Application for a non-material amendment following a grant of planning permission.
Town and Country Planning Act 1990

AW/247/15/NMA

Application for a non-material amendment
following the grant of AW/240/14/HH to reduce
height & width of extension.

Unit:		House number:	14	House suffix:	
Home name:					
Address 1:	TRURO CRESCENT				
Address 2:	ALDWICK				
Address 3:					
Town:	BOGNOR REGIS				
County:	WEST SUSSEX				
Postcode (optional):	PO21 3RQ				
Description of location or a grid reference. (must be completed if postcode is not known):					
Easting:		Northings:			
Description:

sheet 1 a of 2

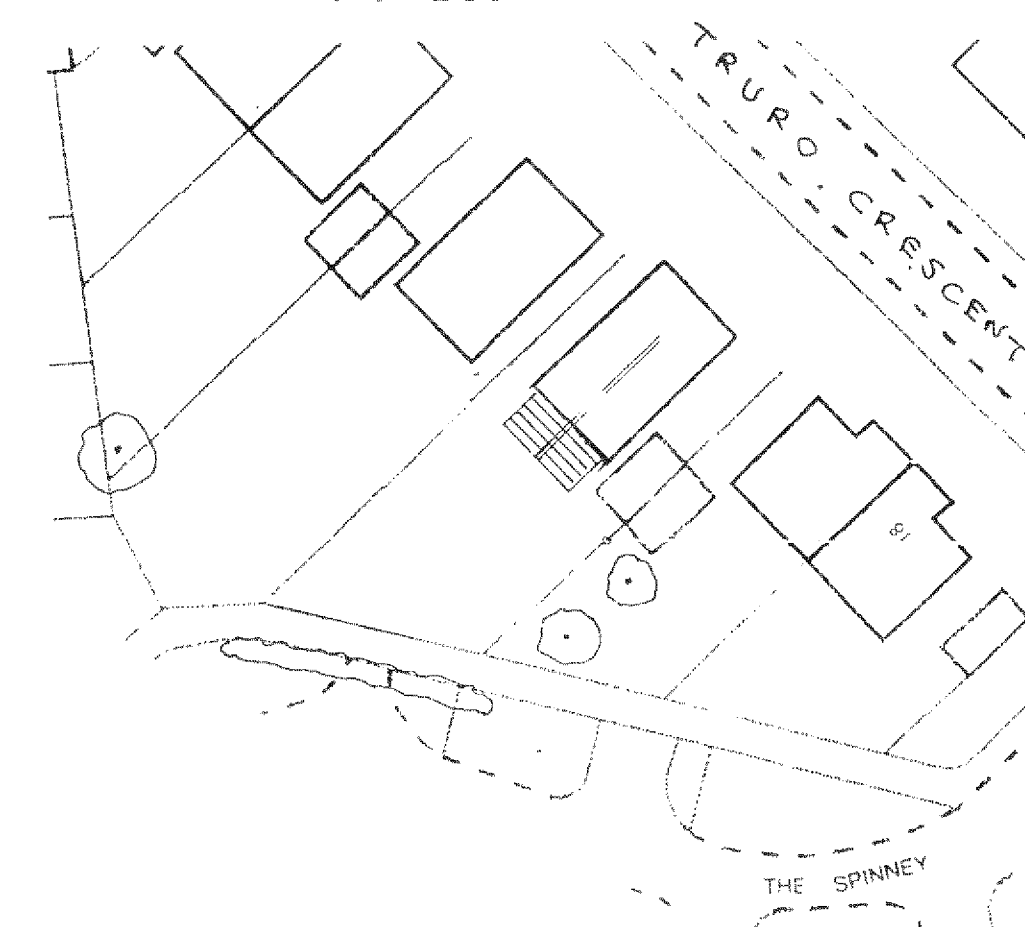
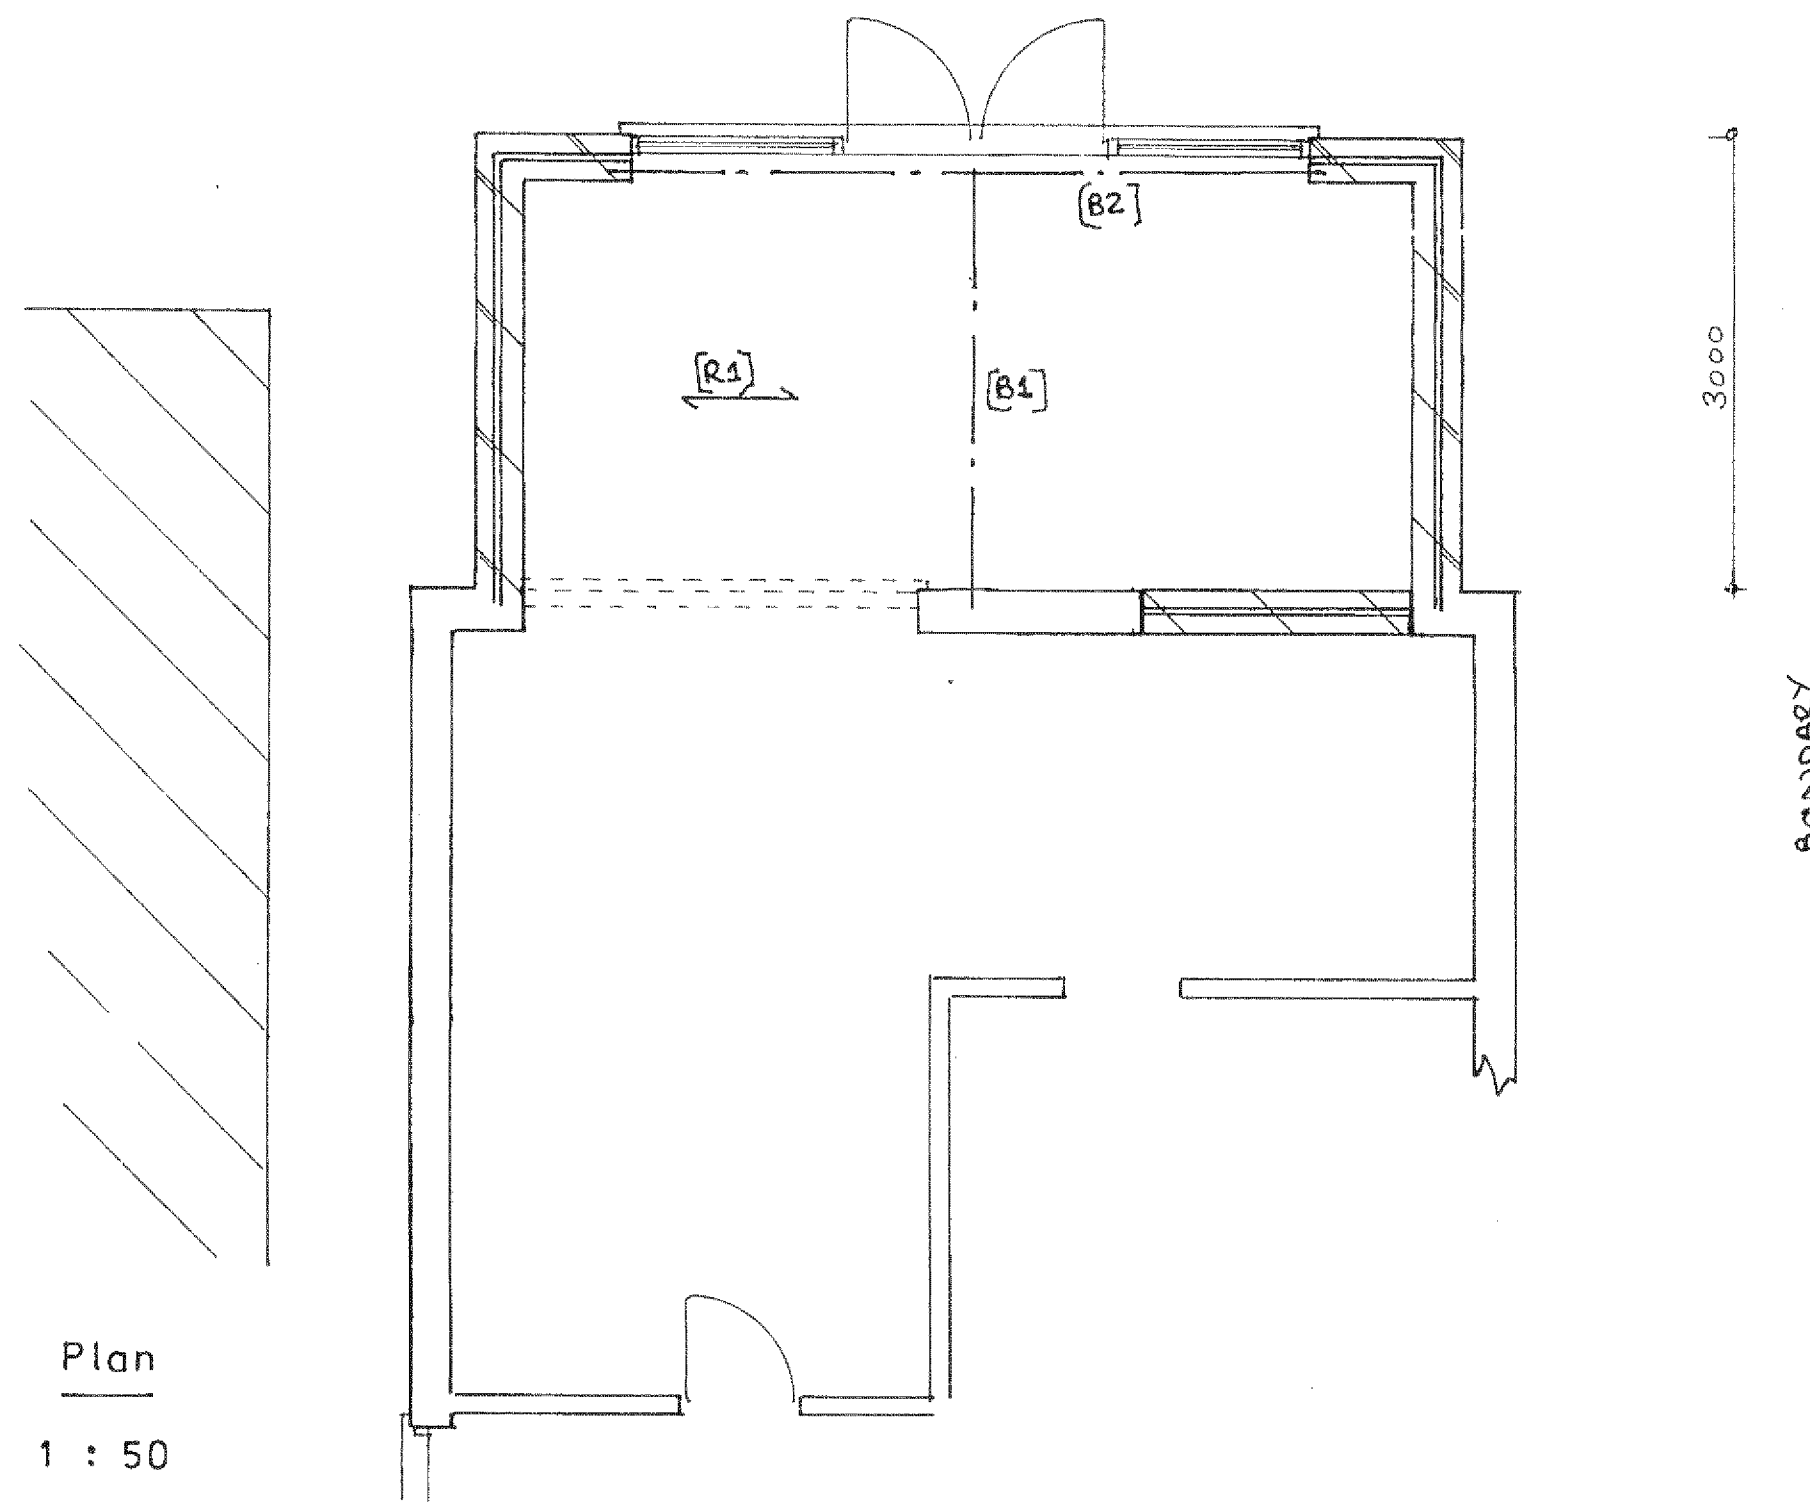
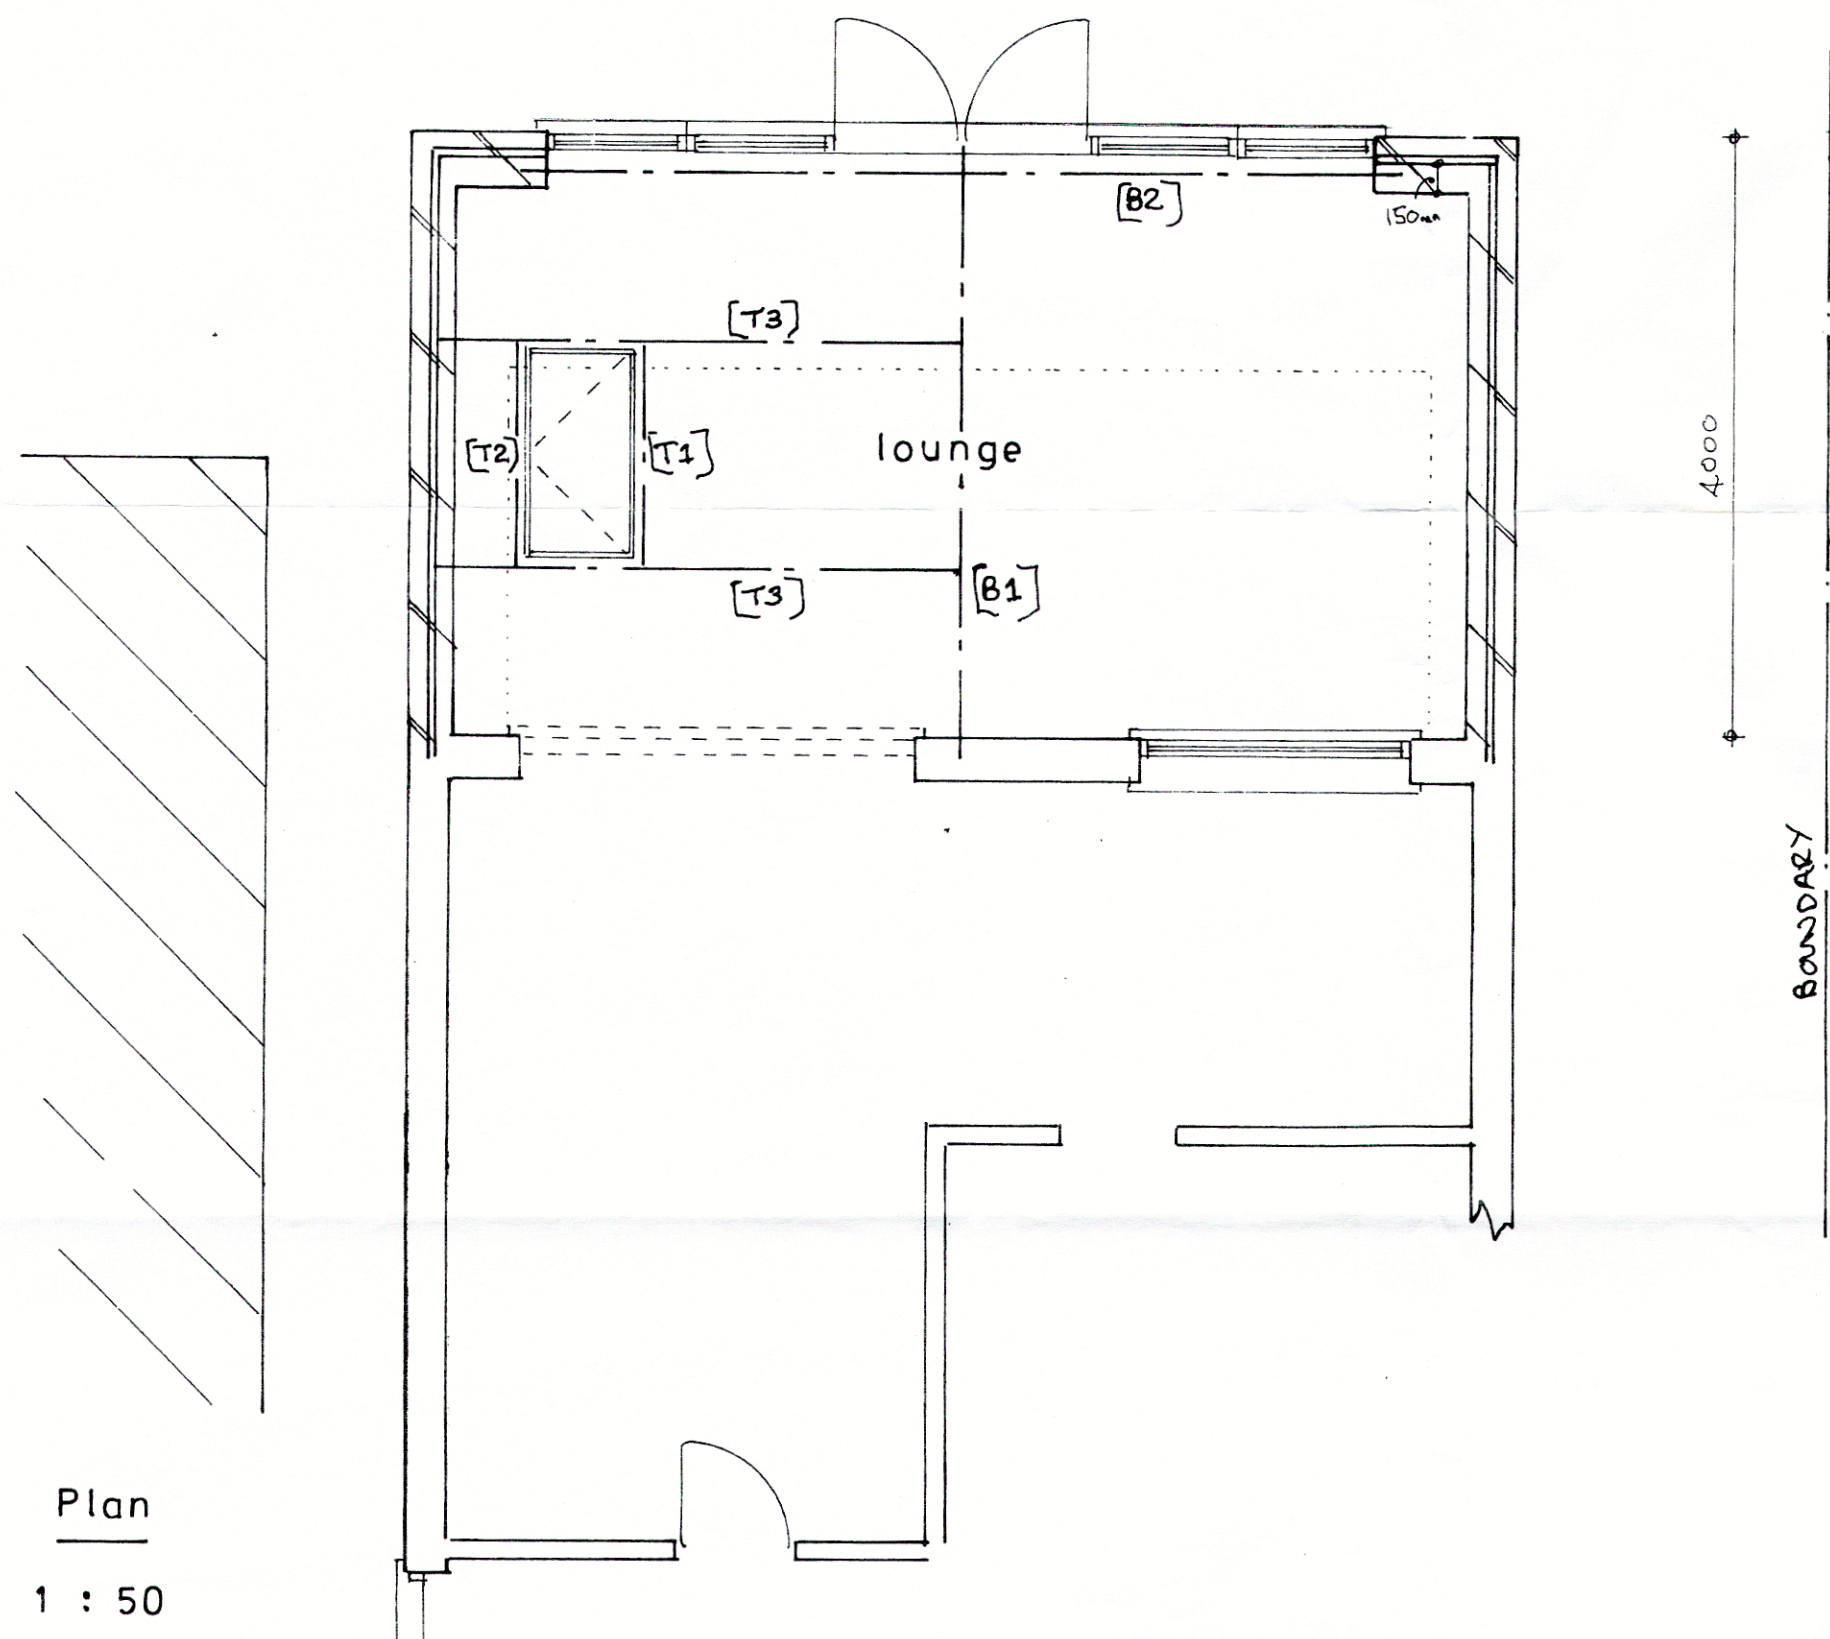
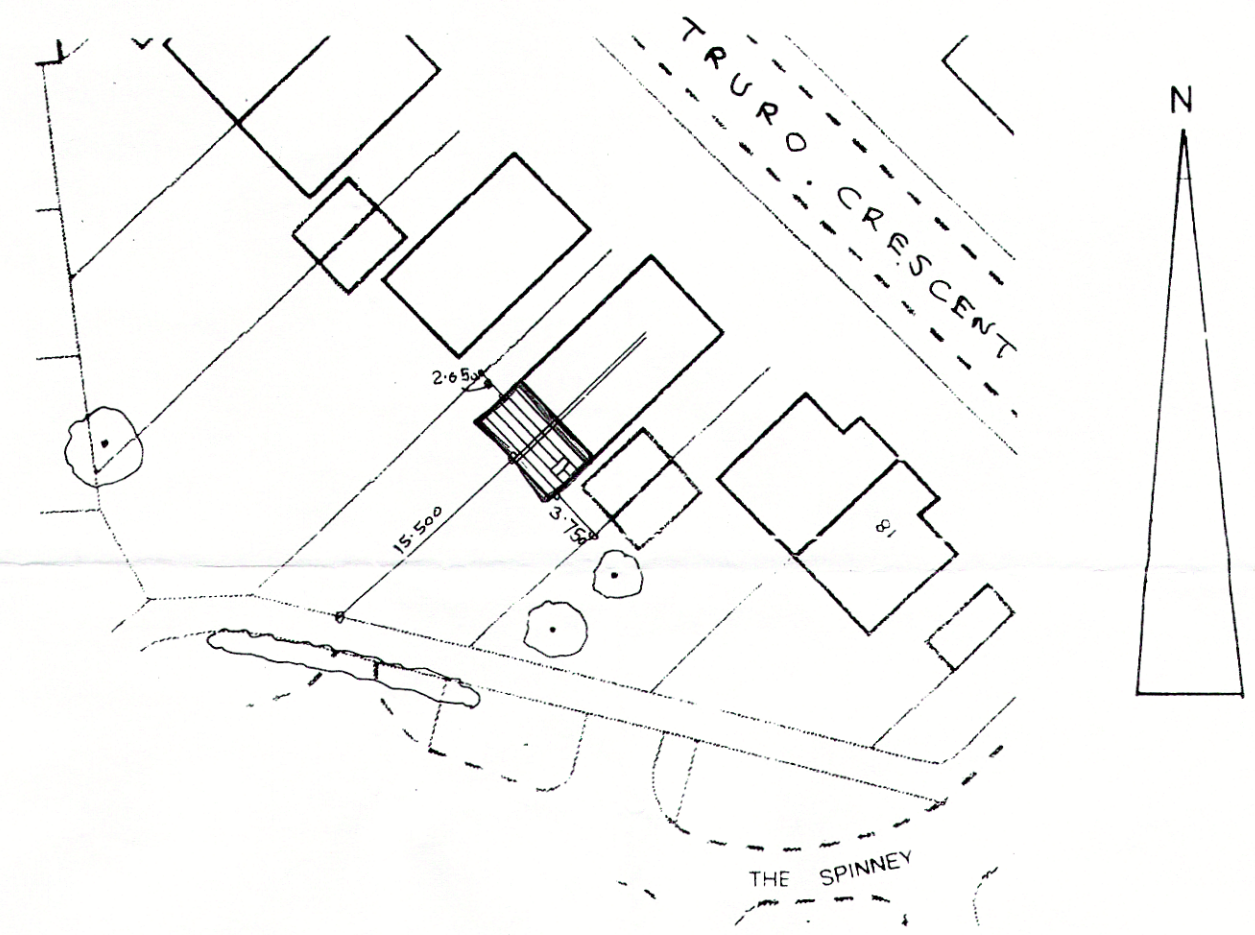
To make the extension smaller than
original drawings.
